## **RESPONSE TO SUBMISSIONS - EASTLAKES SHOPPING CENTRE MOD 1**

This letter has been prepared by Urbis on behalf of Stateland East Unit Trust (The Applicant) regarding MP09\_0146 Mod 1 – Modification to Eastlakes Shopping Centre Mixed Use Development. The Modification was placed on public exhibition from 8 August – 23 August 2017 and submissions were received from the community, local and state agencies.

ADDITIONAL 1B SHADOW

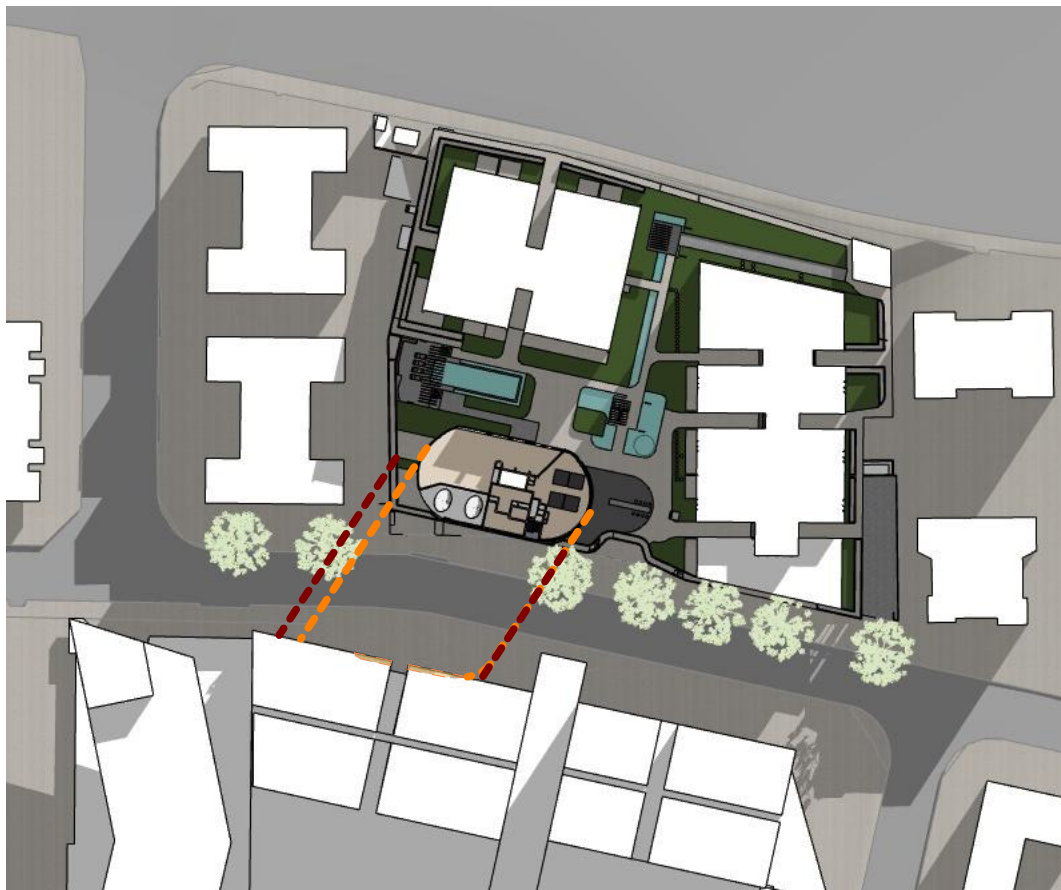
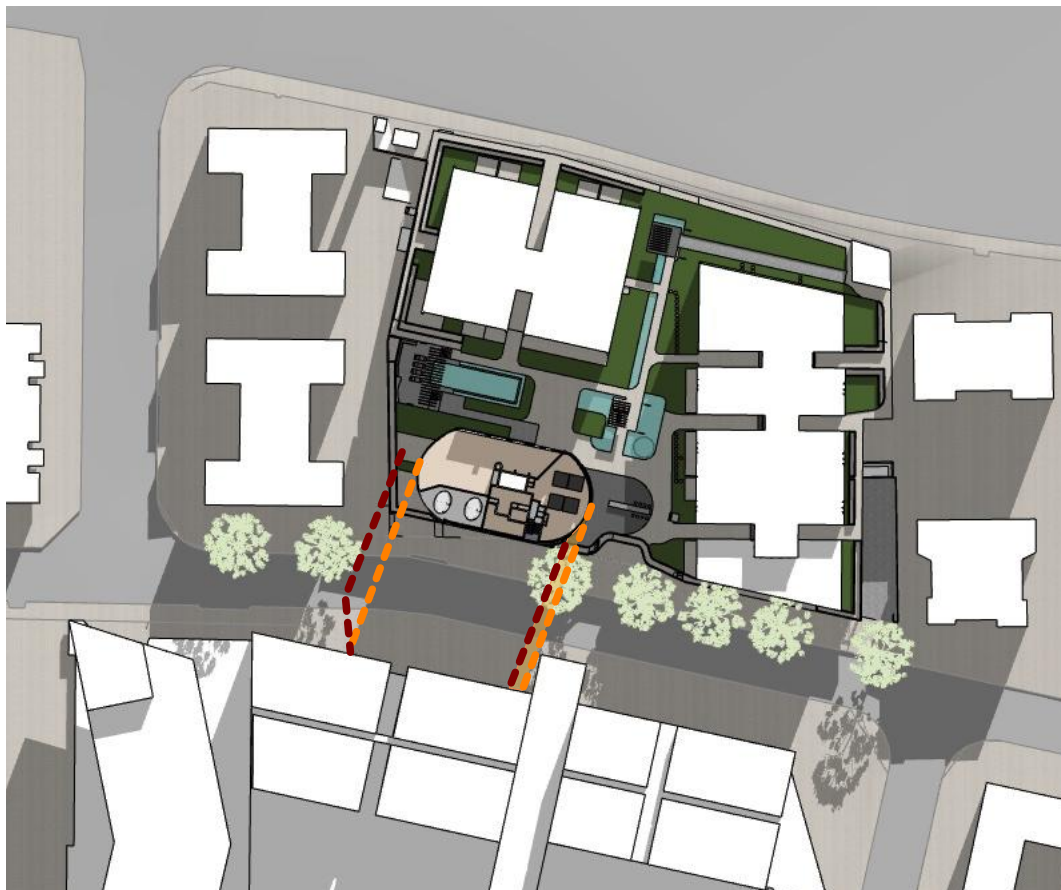
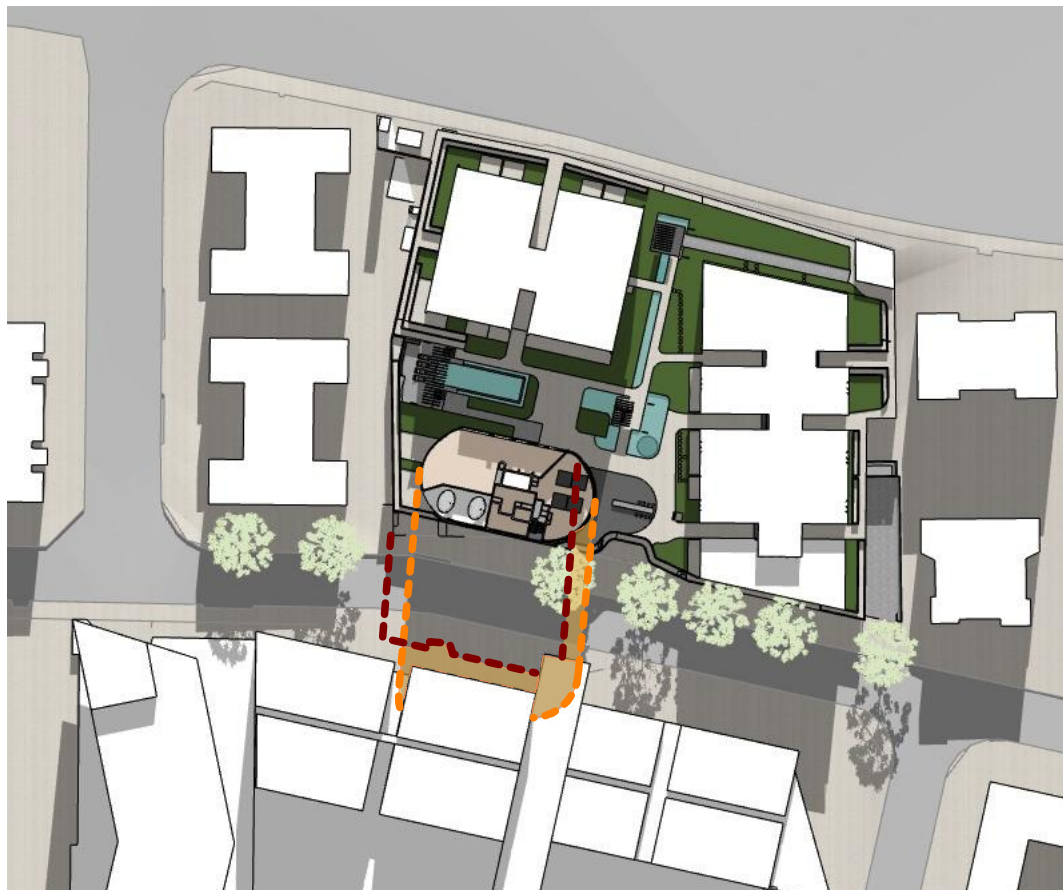
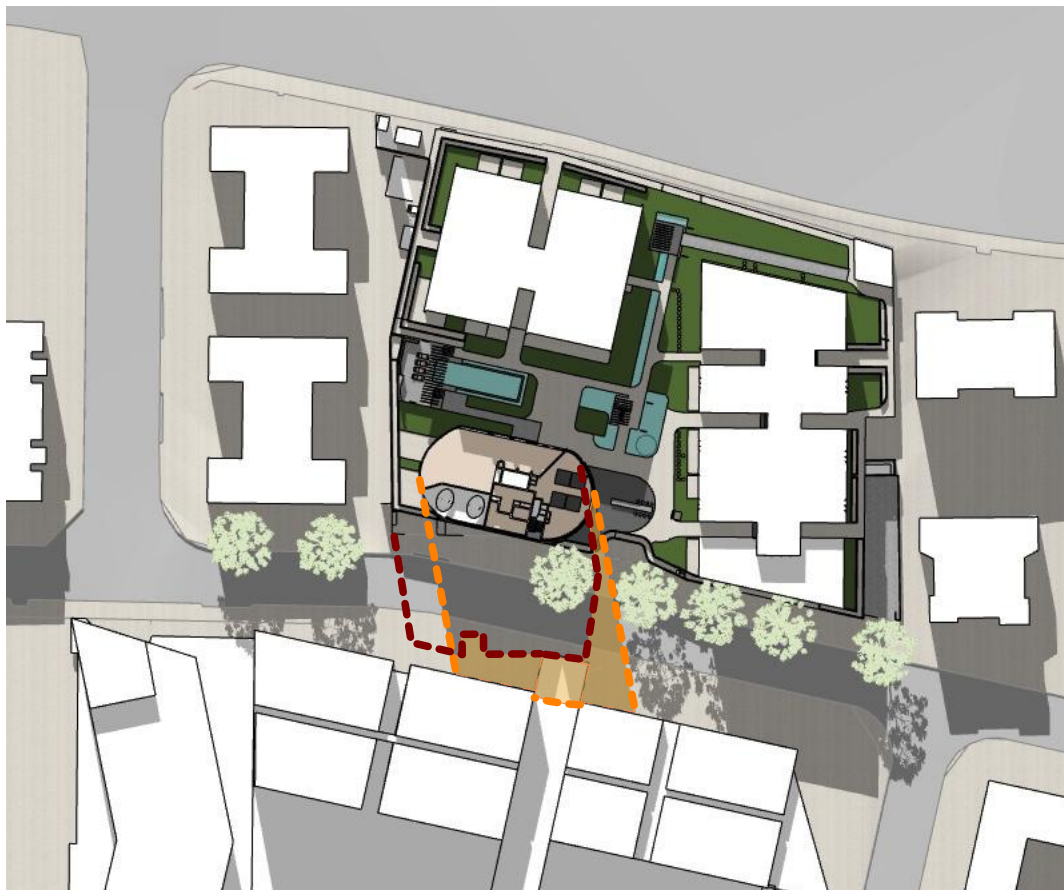
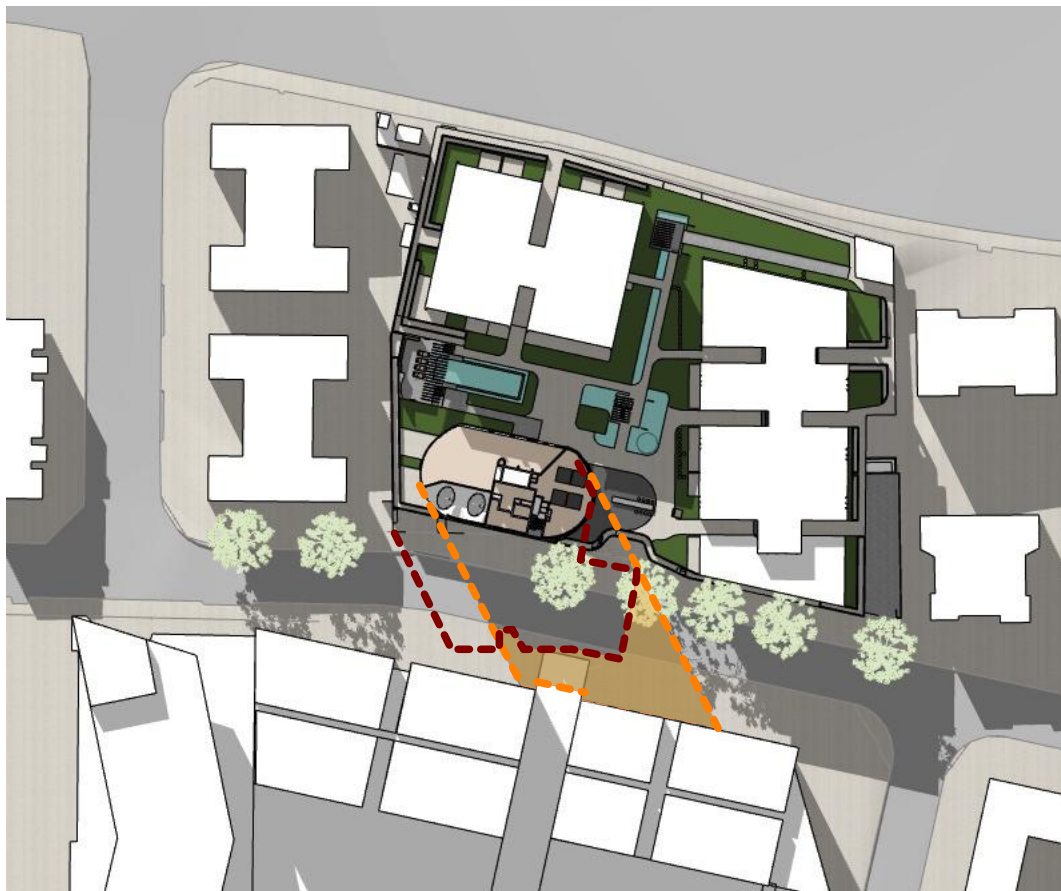
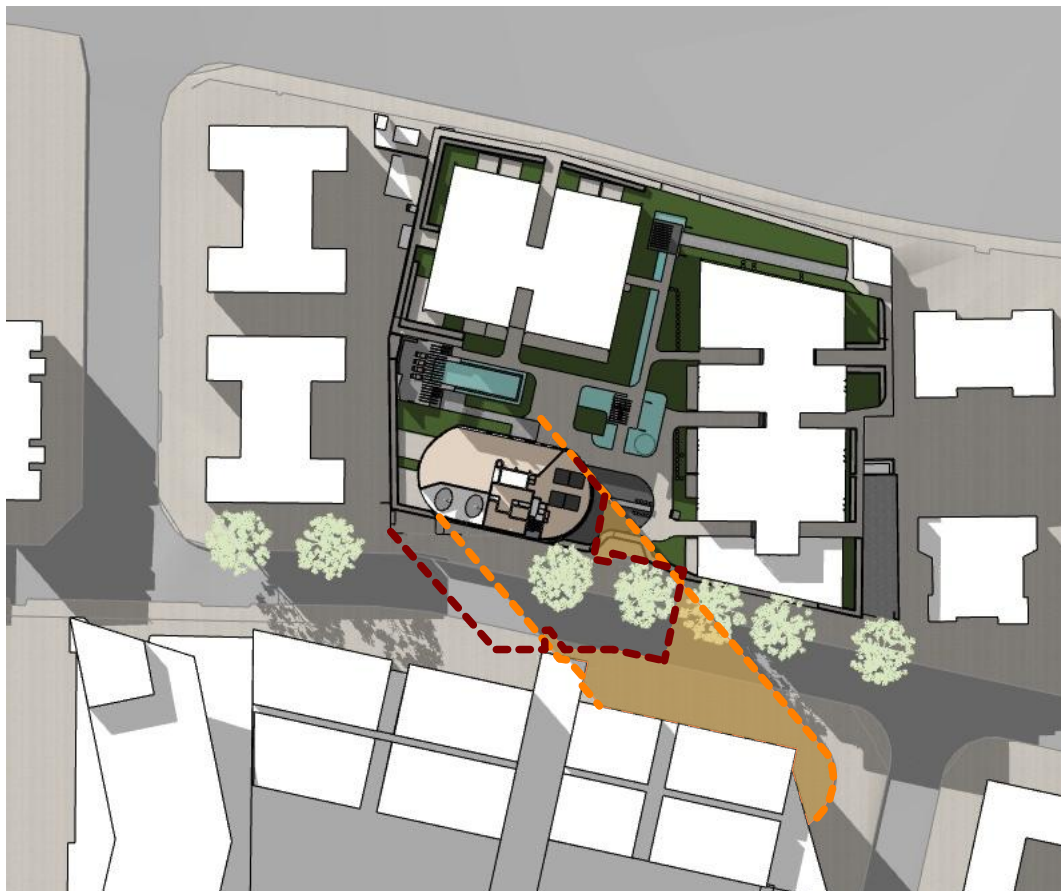
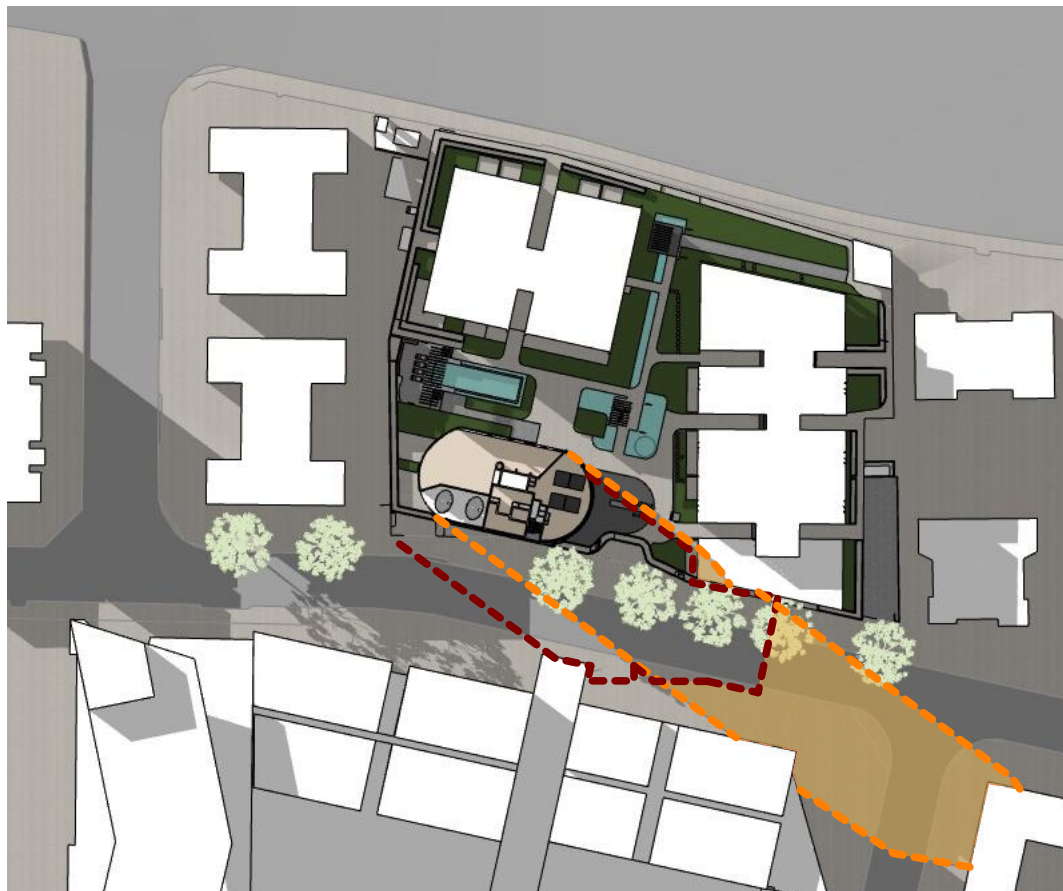
Submission	Response
<b>Department of Planning and Environment</b>	
<p>1. <i>Please provide shadow diagrams showing the additional overshadowing as a result of the increased height for Building 1B.</i></p>	<p>Updated Shadow Diagrams have been prepared by FJMT and are submitted at <b>Appendix A</b>.</p> <p>The diagrams demonstrate that the proposed works sought by this modification result in minor additional shadow impact on existing dwellings. The proposed development has been designed to minimise overshadowing of adjacent properties as far as practical, particularly to the western boundary where the site adjoins 16 Evans Avenue. Due to the increased setback and curvilinear shaped building, the proposed modification results in Building 1B having reduced shadow impact to the west compared to the approved scheme. At no point does shadow cast from Building 1B impact 16 Evans Avenue to the immediate west.</p> <p>Between 11am and 2pm the additional shadow cast by Building 1B is located over Evans Avenue onto the South Site. The shadow is generally fast moving and enables the approved north facing dwellings within Building 3 and some within Building 4 to have access to at least 2 hours of solar access. It is noted that the approval for the South Site is proposed to be revisited. Any modification or new application will need to demonstrate compliance with the solar access design criteria contained in the Apartment Design Guide (ADG).</p> <p>At 3pm the proposal impacts existing dwellings within the existing residential flat building at 34 Barber Avenue. This shadow impact is considered acceptable, as:</p> <ul style="list-style-type: none"> <li>• Only impacts the north-western corner.</li> <li>• Shadow impact is limited to 3pm only, with only minor impact at 2pm.</li> </ul>

Submission	Response
	<ul style="list-style-type: none"> <li>Dwellings within this block are still able to achieve more than 2 hours of solar access, with uninterrupted solar access up until 2pm.</li> </ul> <p>The proposed shadow cast from Building 1B is therefore considered entirely acceptable.</p>
<p>2. <i>Please also provide elevational shadow diagrams clearly showing the additional impact on the adjoining residential building.</i></p>	<p>The modifications subject to this application result in no additional shadow impact to the adjoining residential development at 16 Evans Avenue.</p> <p>This is achieved through the integration of larger setbacks than approved and the curvilinear shaped building.</p> <p>As a result, elevational shadow diagrams are not considered warranted and have not been prepared.</p>
<p><b>Bayside Council</b></p>	
<p>3. <i>It is noted that no master plan has been prepared or endorsed by Council for Eastlakes Town Centre or the wider Eastlakes locality, which would otherwise guide any increase in development density (with appropriate LEP controls). In the absence of such master planning for the Town Centre and immediate locality, Council cannot be supportive of further substantial intensification beyond the previous Part 3A approval. The preparation of a Master Plan would provide opportunities for stakeholder participation during its preparation, including consultation with relevant government agencies, in accordance with the relevant provisions of the EP&amp;A Act.</i></p>	<p>It is recognised that there is no Master Plan in force to guide additional development density within the Eastlakes Local Centre.</p> <p>There was also no Master Plan in force to support the approval of MP09_0146. The proposed modification of Building 1B and minor inconsequential amendments to the North Site are considered to be of limited environmental impact and consistent with the existing approval as demonstrated within the submitted EAR and is therefore a modification of the original approval. The proposed additional gross floor area (GFA) of 1,778.5m<sup>2</sup> sought by the proposed modification is not considered to warrant the preparation of a local centre Master Plan, if one was not required as part of the original approval for 49,040m<sup>2</sup>. Such an increase does not constitute a substantial intensification of the site from an operational impact perspective given the proposed addition of residential and retail floor space represents an additional 0.07:1 of FSR to a much greater overall floor space and centre approach. The proposed modifications therefore should be treated under the same assessment criteria as the original Part 3A Approval.</p> <p>In the absence of a local centre Master Plan, the proposal has sought to respond to the local and state strategic planning framework. Specifically, the revised draft</p>
